| Consultation Response from KC Waste Strategy (Refuse & Cleansing) | | |
| PA no. & address: 2021/92086 land at, Bradley Villa Farm, Bradley Road, Bradley, Huddersfield, HD2 2JX | | |
| Proposal: Erection of 270 residential dwellings and associated infrastructure and access | | |
| Date Responded: 23/06/2021 | Responding Officer: Carol Oakden | Responding Ref: WPS-21-027 |

MARKETING NAME: -
 PROJECT: BRADFORD ROAD HUDDERSFIELD
 TITLE: SHARED DRIVE TRACKING PLAN

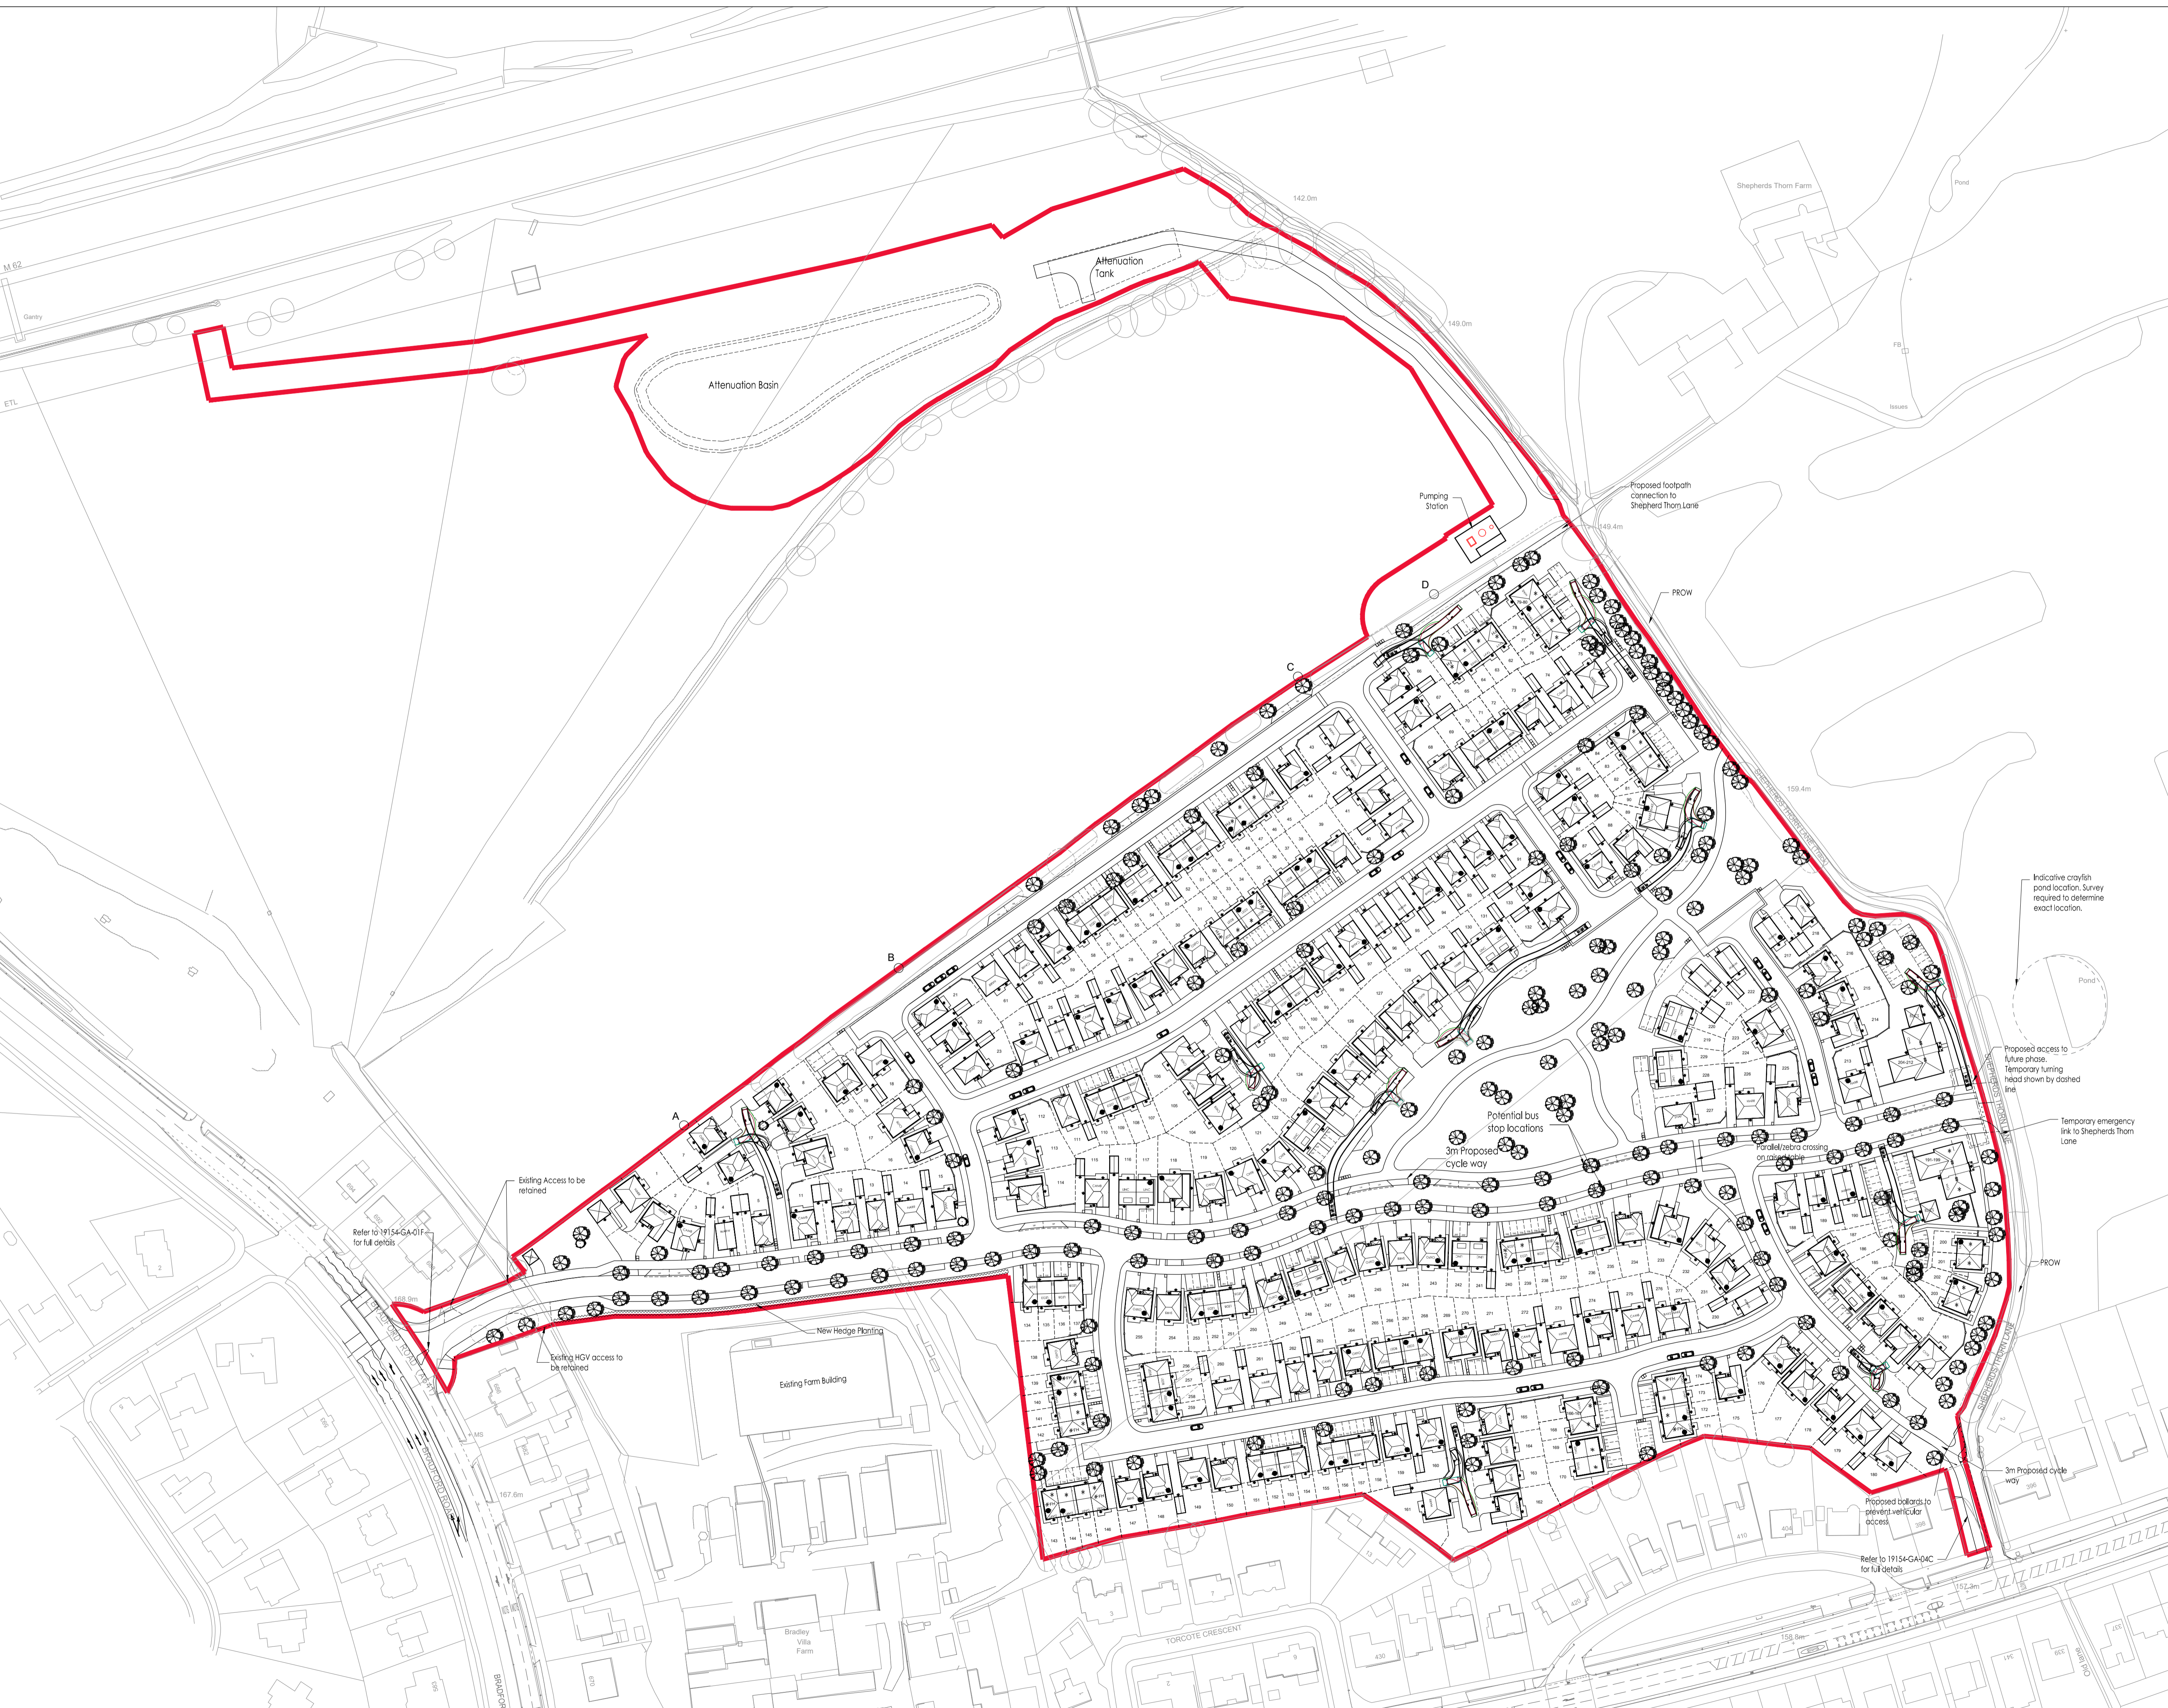
- Communal presentation points are required for properties on shared private driveways of which there are several on the submitted layout plans. The Authority will not routinely take a refuse collection vehicle (RCV) into unadopted roads and therefore space must be identified for bins to be presented on collection day in a convenient location without causing obstruction.

- The site layout includes 11 cul-se-sacs and these create the need for reverse manoeuvres for RCVs, often along the full length of the street if parking is a regular problem in turning heads. It is noted that the cul-de-sac turning heads are mostly designed to lead to driveways or private roads, thereby helping to discourage on-street parking within the turning space. Nevertheless, looped road layouts are strongly preferred.
- Parked cars are a perpetual problem for RCV access and as such it is important to account for potential parking spaces, even where these are undefined, in the swept path analysis. It appears there is no visitor parking proposed on the site. This will exacerbate on-street parking and potentially create access difficulties for waste collections.
